CITY OF ALBUQUERQUE

December 17, 2015

RE: Westgate Heights Park Addition, Unit 2 (File: M09D008B)
8810 Sonya Ave. SW
Grading Plan and Drainage Plan
Engineer's Stamp Date – 12/010/2015

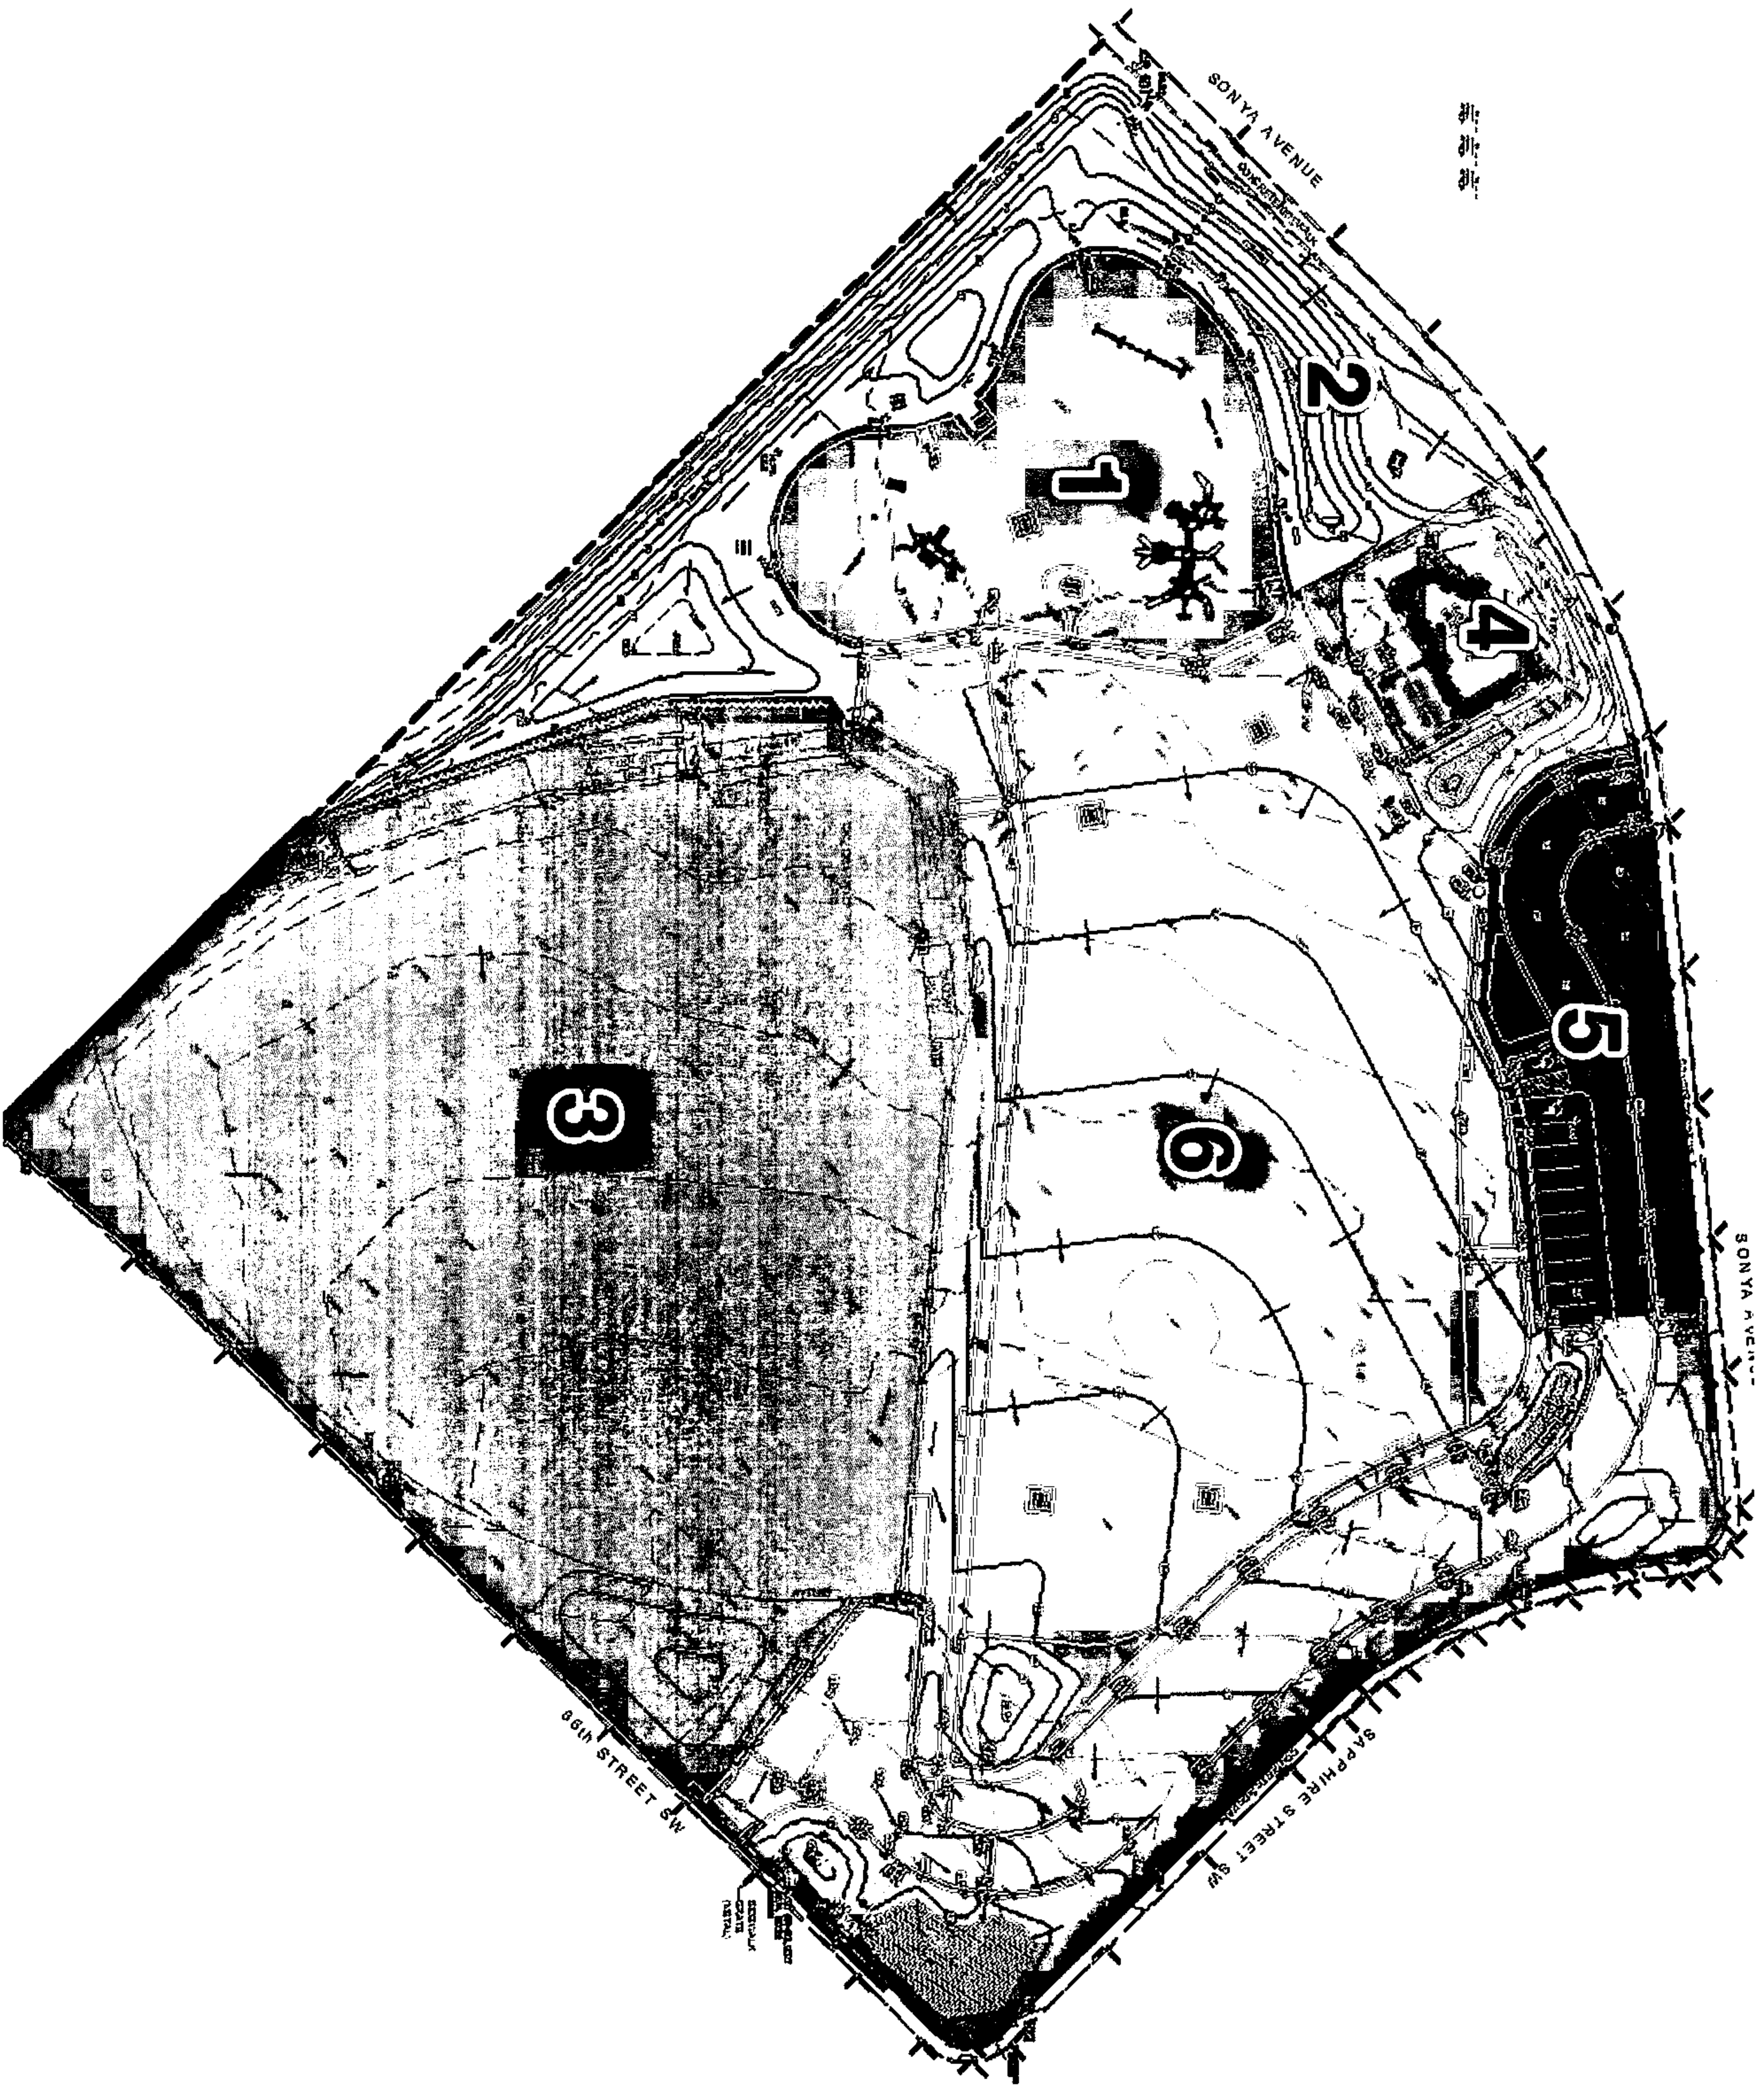
- Provide spot and contour elevations on the Overall Grading and Drainage Plan sheet.
- Provide flow line elevations at the outfall for each proposed sidewalk culvert onsite.
- The total area for historic flows does not match the total area for developed flows in the Calculation section of the Overall Grading and Drainage Plan sheet. Review this information to ensure the total basin area for existing and proposed conditions match.
- The area of land treatment D used in the First Flush calculation shown appears to be based on information provided in the previous submittal. Update the First Flush calculation on the Grading General Notes and Details sheet to reflect the changes to the area of land treatment D shown in the Calculation section of the Overall Grading and Drainage Plan sheet.
